Engineers Comments Regarding Surface Water Drainage

APPLICATION NO: P/18/20/PL

Site Address: Land west of Barton House Manor Park Pagham E2 9LJ

Description of Works: Change of use from highway land to residential use for the development of 4 No. 3 bed terraced houses with associated parking & access. This application affects the setting of a listed building.

TYPICAL SOAKAWAY DETAIL
Scale 1 : 20
Aquavoid Soakaway Boxes

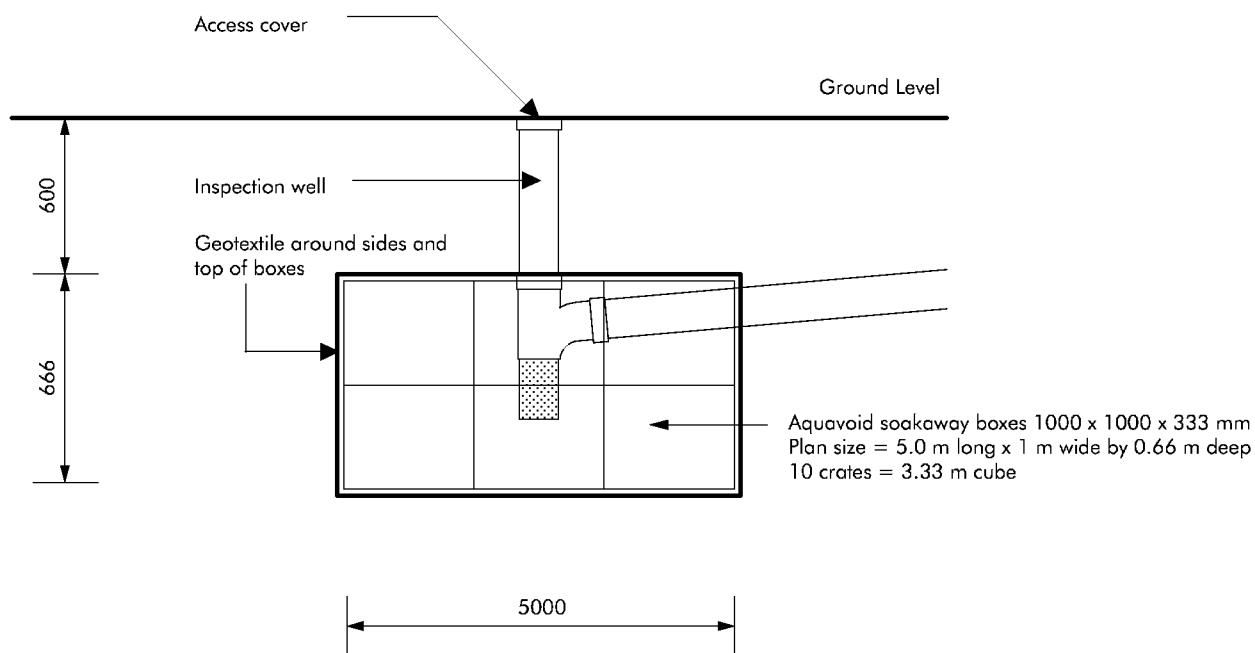
The applicant indicates that if the application is successful the site will drain surface water by infiltration. We are agreeable to this, however the design will need to be informed by winter infiltration tests in strict accordance with BRE365 and a full winter's groundwater monitoring. In addition, our records show that a foul sewer may cross this site, please consult Southern Water regarding this. If you are minded to approve the application please apply the following conditions to ensure that the development is adequately drained and does not increase flood risk elsewhere.

“Development shall not commence, other than works of site survey and investigation, until full details of the proposed surface water drainage scheme have been submitted to and approved in writing by the Local Planning Authority. The design should follow the hierarchy of preference for different types of surface water drainage disposal systems as set out in Approved Document H of the Building Regulations, and the recommendations of the SuDS Manual produced by CIRIA. Winter groundwater monitoring to establish highest annual ground water levels and winter Percolation testing to BRE 365, or similar approved, will be required to support the design of any Infiltration drainage. No building / No part of the extended building shall be occupied until the complete surface water drainage system serving the property has been implemented in accordance with the agreed details and the details so agreed shall be maintained in good working order in perpetuity.”

“Infiltration rates for soakage structures are to be based on percolation tests undertaken in the winter period and at the location and depth of the proposed structures. The percolation tests must be carried out in accordance with BRE365, CIRIA R156 or a similar approved method and cater for the 1 in 10 year storm between the invert of the entry pipe to the soakaway, and the base of the structure. It must also have provision to ensure that there is capacity in the system to contain below ground level the 1 in 100 year event plus 40% on stored volumes, as an allowance for climate change. Adequate freeboard must be provided between the base of the soakaway structure and the highest recorded annual groundwater level identified in that location. Any SuDS or soakaway design must include adequate
